Thank you for inviting the City to comment on the proposed modification of SSD 6960 (Mod 2) to adjust the levels of the basement slab to align with concurrent modifications to the Stage 1B Public Domain SSD 7944. Council provides the following comments:

Figure 5 | Comparison of approved plan (above) and proposed plan (below) with the proposed changes bubbled in red (Base source: EIS SSD 6960 MOD 2)

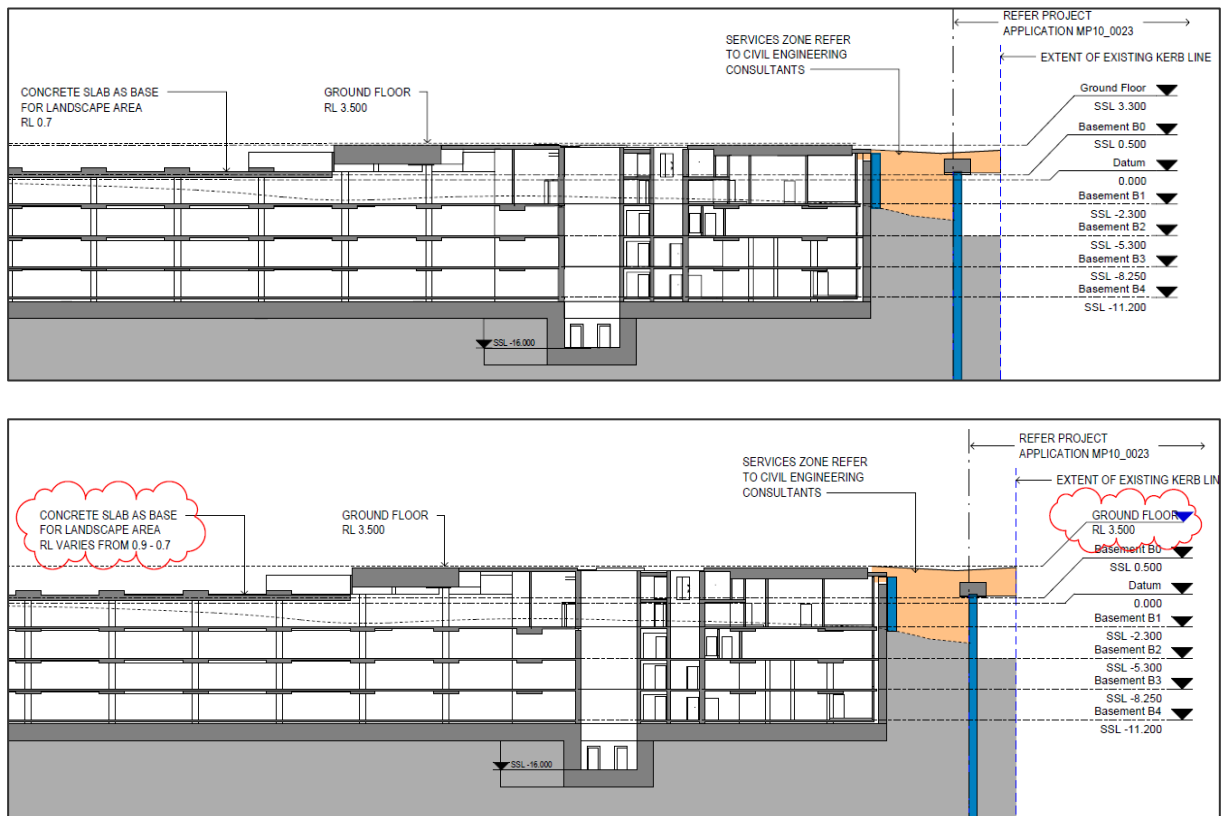
The changes to levels are incrementally minor and are coming via several different modifications, however the overall implications of these changes result in Hickson Park becoming increasingly inaccessible through raising the levels and introducing a seating wall that creates a barrier and mounding the grass. This is not a good outcome for a public open space. The current proposal to elevate levels of the Hickson Park result in a 500mm high wall to the Hickson Road edge, separation between public domain and park, poor permeability and connectivity, and the reduction in universal access for all users. Meanwhile the elevated park levels to Barangaroo Avenue result in walls up to 700mm high.

It is recommended that a condition be imposed to 'cap' future level changes with a maximum ground level and structural slab level.
